SUBJECT: Westconnex M4 Widening (SSI-6148) – Submission to exhibition of Environmental Impact Statement

AUBURN CITY COUNCIL SUBMISSION

AUBURN CITY COUNCIL SUBMISSION TABLE

Figure 8.2 Parramatta Road and M4 Motorway traffic - Base 'do minimum' and M4 Widening scenarios (2021)

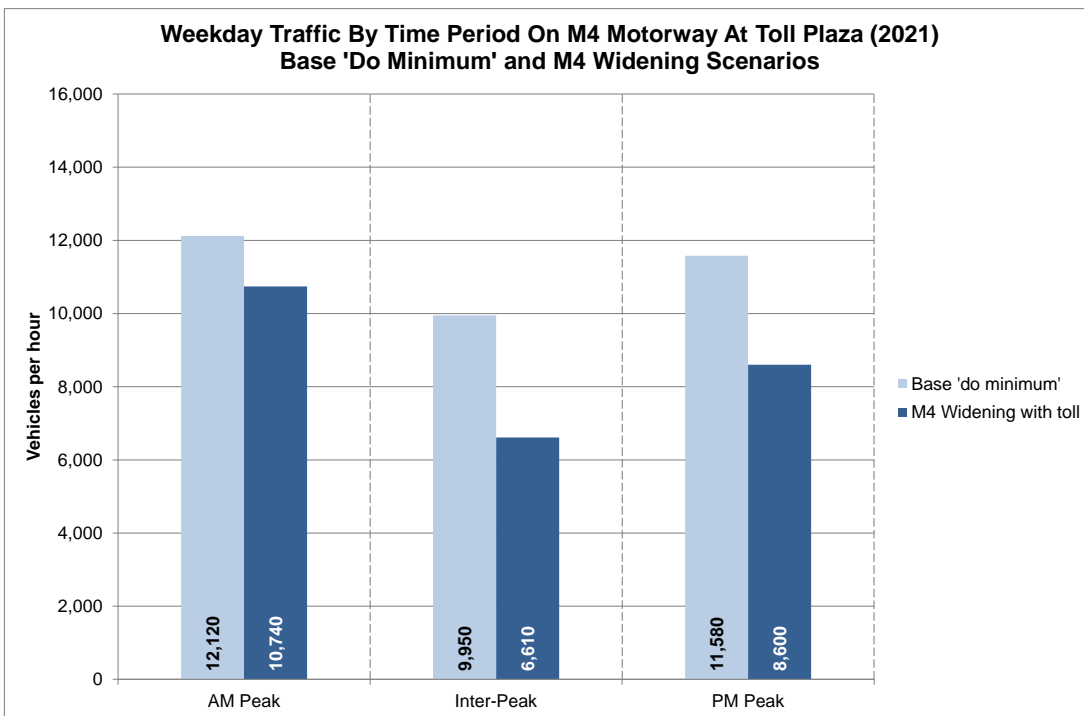
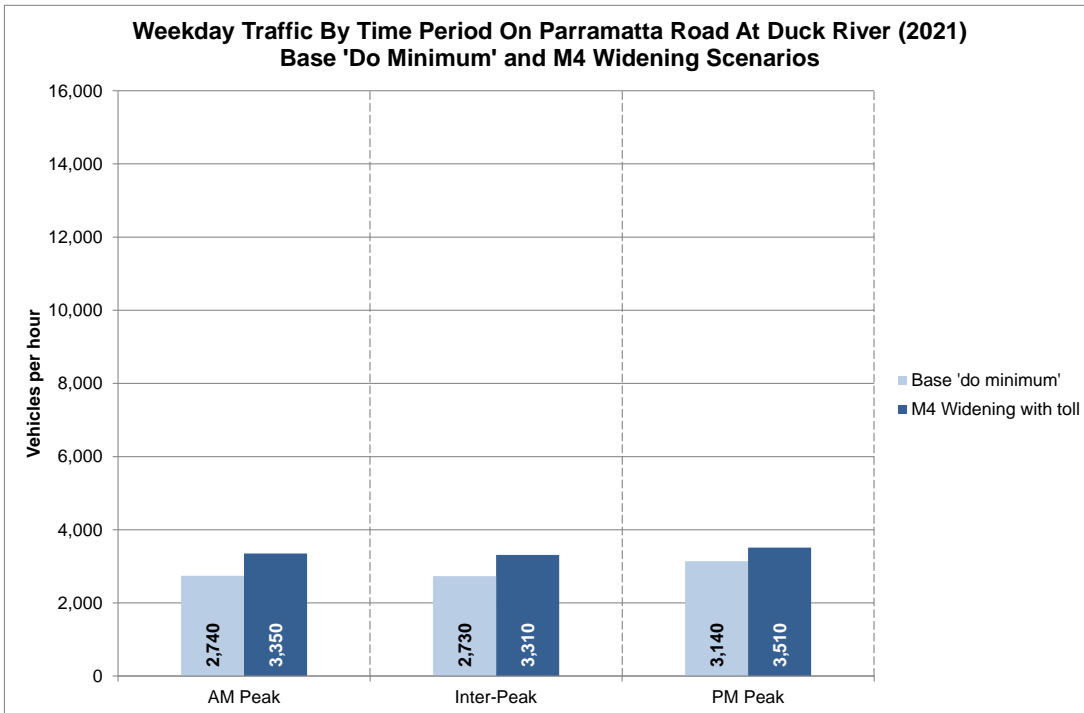
| Requested addition to DGRs | Justification / comments | EIS reference | EIS statement | Council response |
|-----------------------------------------------------------------------------------------------------------------------------------------------------------------------------------------------------|-------------------------------------------------------------------------------------------------------------------------------------------------------------------------------------|-----------------------------------------------------------------------------------------------------------------------------------------------------------------------------------------------------------------------------------|---------------------------------------------------------------------------------------------------------------------------------------------------------------------------------------------------------------------------------------------------------------------------------------------------------------------------------------------------------------------------------------------------------------------------------------------------------------------------------------------------------------------------------------------------------------------------------------------------------------------------------------------------------------------------------------------------------------------------------|---------------------------------------------------------------------------------------------------------------------------------------------------------------------------------------------------------------------------------------------------------------------------------------------------------------|
| <p>Additional traffic on Parramatta Road</p> <p>The application should model the likely short, medium and long term impacts on Parramatta Road, including during the construction phase.</p> | <p>Once the application is exhibited, Council will need to be provided with information about the proposal's impact on Parramatta Road in order to provide meaningful comments.</p> | <p>Section 8.1.5 – Assessment of potential operational traffic and transport impacts</p> <p>Tables 8.5 and 8.6</p> <p><i>Not addressed in Section 7.4.2 – Issues raised by government agencies and councils and Table 7.1</i></p> | <p>Section 8.1.5 of the EIS shows that WestConnex will result in a significant increase in traffic on alternative west-east routes including Parramatta Road, Victoria Road and the M2 Motorway, primarily due to toll avoidance.</p> <p>The modelled increase in traffic on Parramatta Road, shown in Tables 8.5 and 8.6, from the 2021 Base “do minimum” case to the M4 Widening case is 35% (from 43,990 to 59,370). While the increase in traffic on Parramatta Road from the 2031 Base “do minimum” case to the Full WestConnex is 20% (from 52,030 to 62,490).</p> <p>Further, the modelling figures provided do not show where all the M4 traffic will be redirected to, resulting in considerable uncertainty about</p> | <p>Council requests a commitment to upgrade key intersections along Parramatta Road and the Auburn LGA local road network that will be detrimentally affected by M4 widening / WestConnex. These include, but are not limited to Parramatta Rd/Rawson Rd Auburn, and Parramatta Rd/Hill Rd, Homebush Bay.</p> |

| Requested addition to DGRs | Justification / comments | EIS reference | EIS statement | Council response |
|----------------------------|--------------------------|---------------|------------------------------------------------------------------------------------------------------------------------------------------------------------------------------------------------------------------------------------------------------------------------------------------------------------------------------------------------------------------------------------------------------------------------------------------------------------------------------------------------------------------------------------------------------------------------------------------------------------------------------------------------------------------------------------------------------------------------------------------------------------------------------------------------------------------------------------------------------------------------------------------------------------------------------------------------------------------------------------------------------------------|------------------|
| | | | <p>the impacts of the proposal on traffic on other Sydney roads, as follows:</p> <ul style="list-style-type: none"> • The modelling shows a decrease in M4 traffic in 2021 of 64,728, but only 31,084 vehicles movements are accounted for in the main east-west routes, a shortfall of 33,664. • The modelling also shows a decrease in M4 traffic in 2031 of 25,420, but only 18,390 vehicles movements are accounted for in the main east-west routes, a shortfall of 7,030. <p>It can reasonably be assumed that the majority of this unaccounted traffic will redirect onto the local road network near the M4, such as those within the Auburn LGA.</p> <p>The redirection of increased traffic to Parramatta Rd will reduce its amenity, which is inconsistent with the stated intent of the WestConnex to support the revitalisation of Parramatta Rd. It will also disadvantage bus commuters, as buses will also be delayed by the additional congestion on Parramatta Rd.</p> | |
